Department of Transportation

RE: Waterbury Filings Nos.1 and 2 PUD PP - PUDSP215

The Master Development Drainage Plan & Preliminary Drainage Report for Waterbury Filings No. 1 & 2 dated March 2022 and the Grading, Erosion & Sediment Control Plan for Waterbury Filings No. 1 & 2 dated July 20, 2022 have been reviewed by a CDOT Hydraulics Engineer. Their comments follow:

POND 1 DETAILS

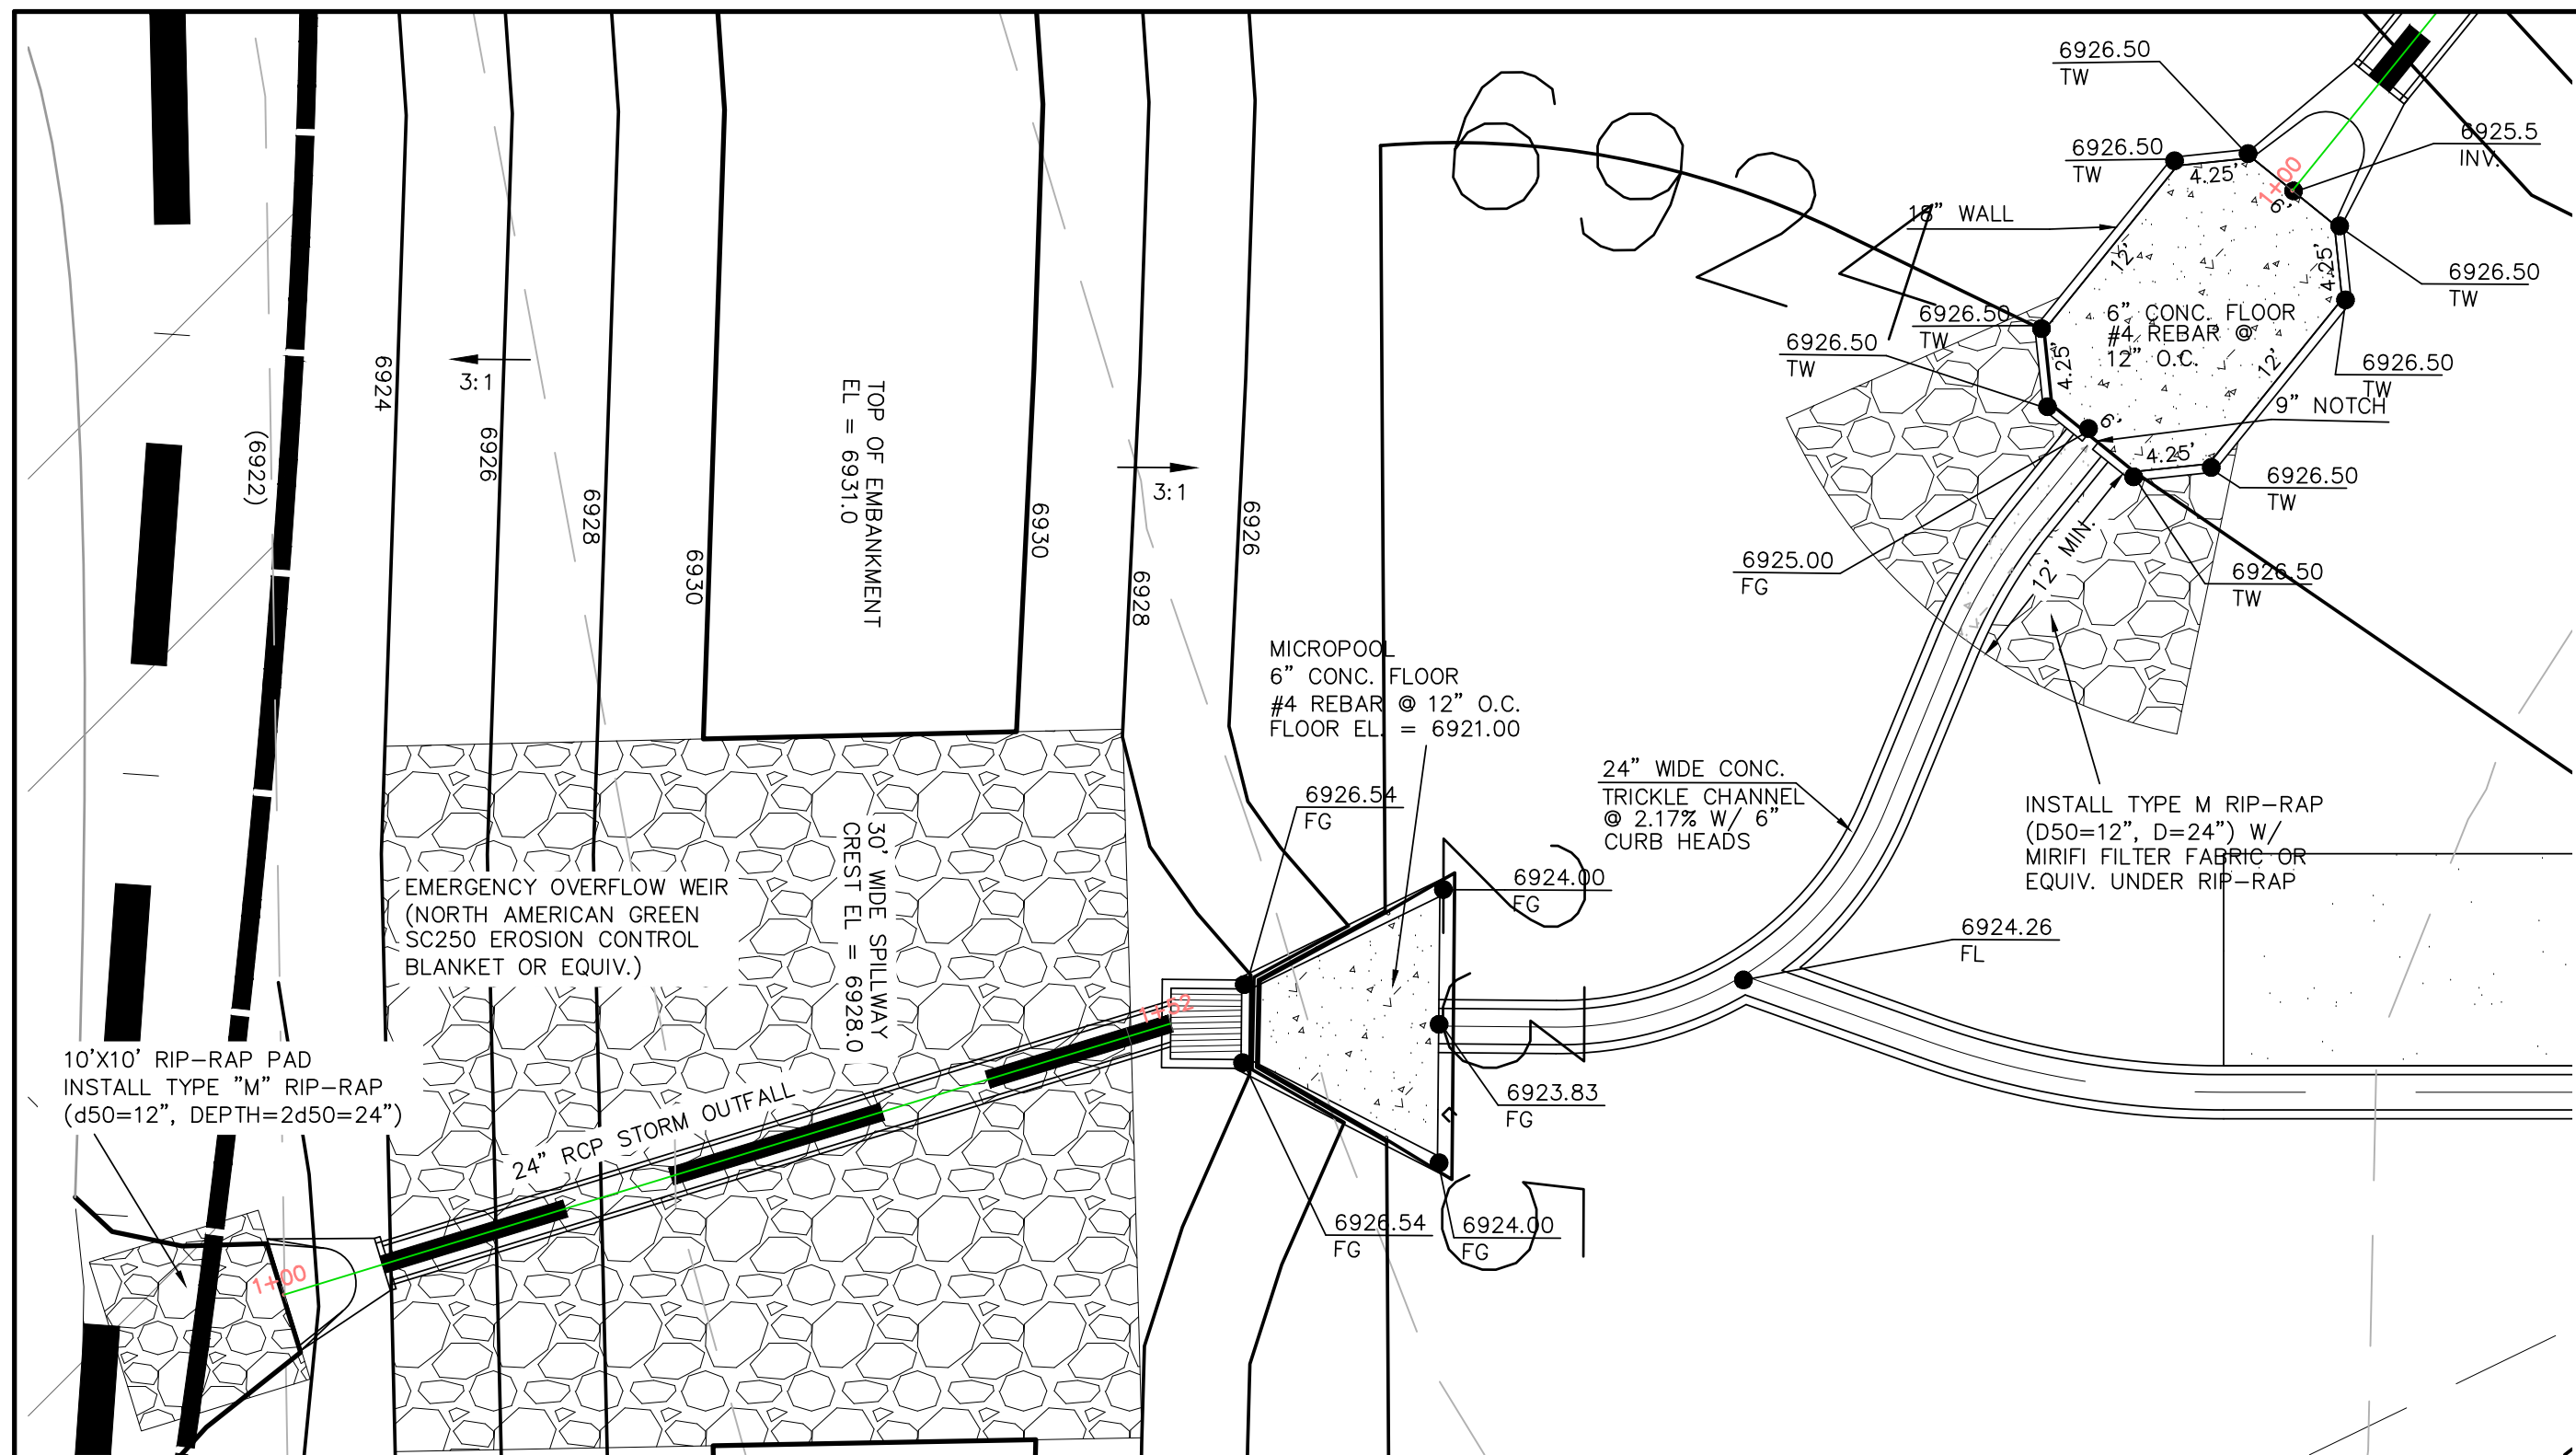
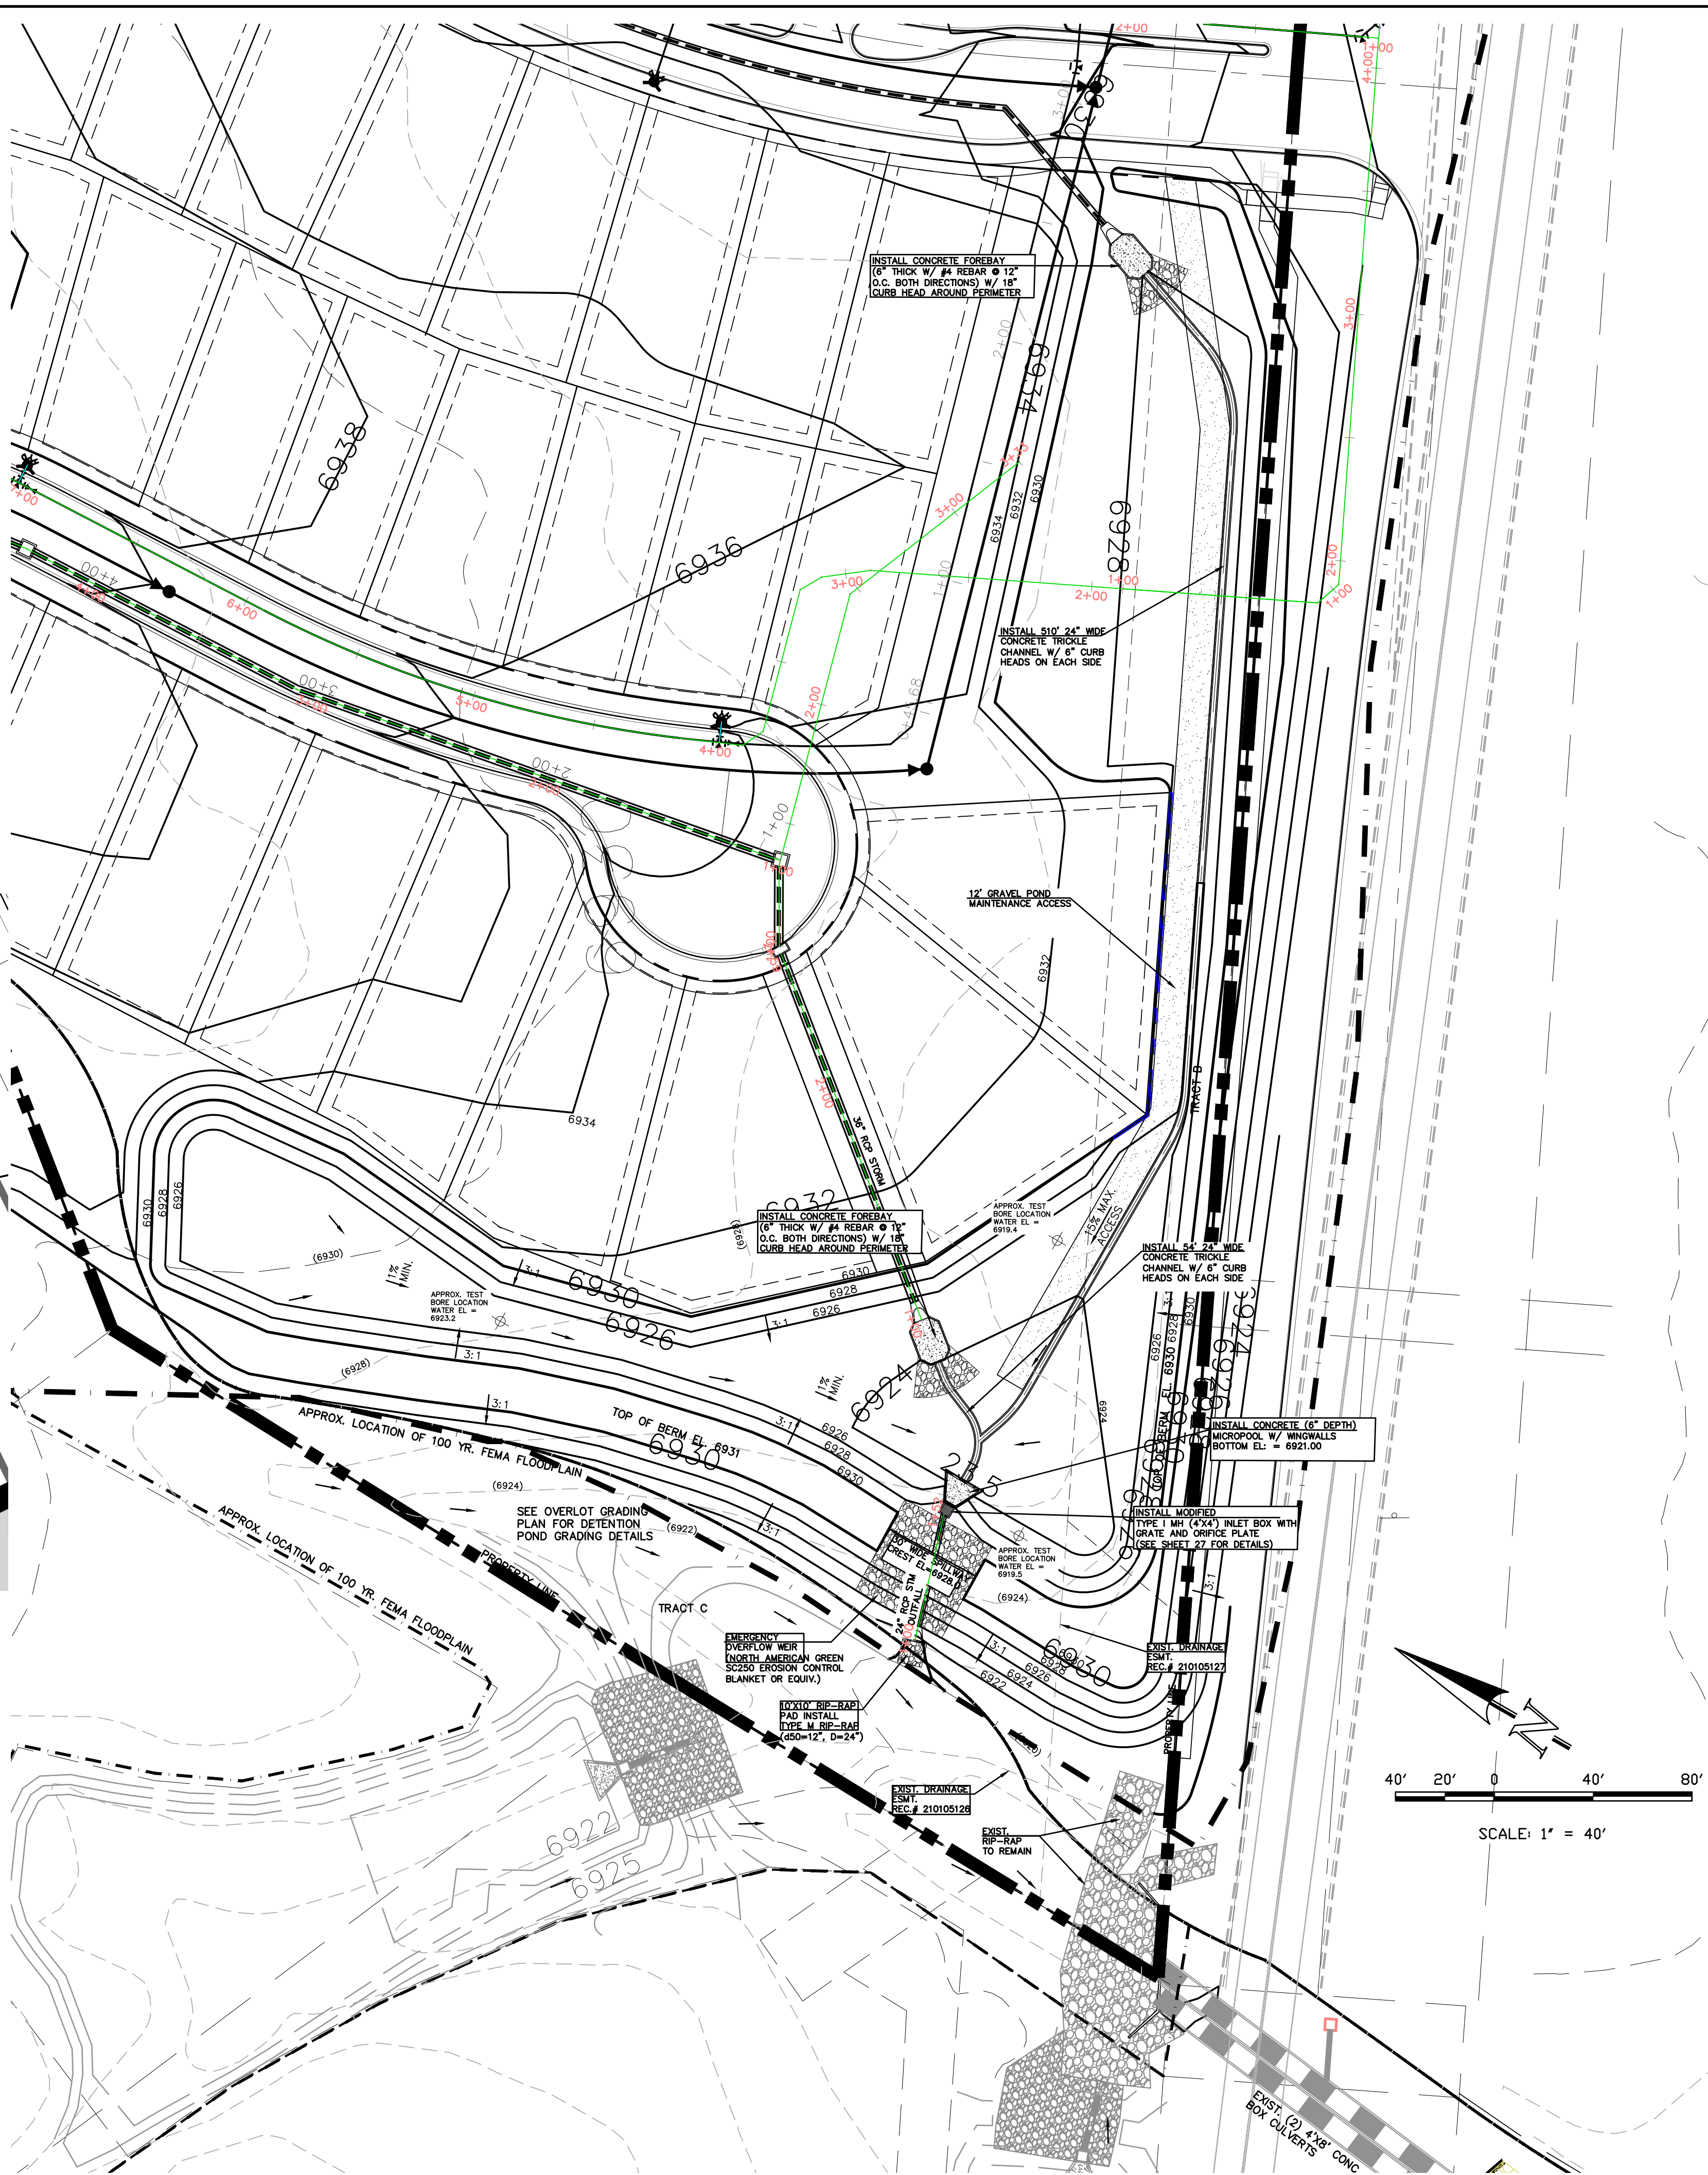
- Note: The construction set was not resubmitted in this submittal. The construction set from the previous submittal (October 2021) was reviewed and compared to the inputs in the H&H calculations.
- Basin forebays are located concerningly close to the outlets. Consider revising the layout of the detention basins to prevent short-circuiting the basin. Refer to the CDOT Drainage Criteria Manual (DDM) Chapters 12 and 16 for further guidance.

- Ensure all inputs on the Detention Basin Outlet Structure Design sheets (pages 175, 181, and 187 of the drainage report) match the construction plans and resolve all inconsistencies.

- Pond 1 ratio peak outflow to predevelopment Q is greater than 1.0 for 5-year and 10-year. (Page 175 of drainage report)
 - Pond 2 ratio of peak outflow to predevelopment Q is greater than 1.0 for the 10-year event. (Page 181 of drainage report)
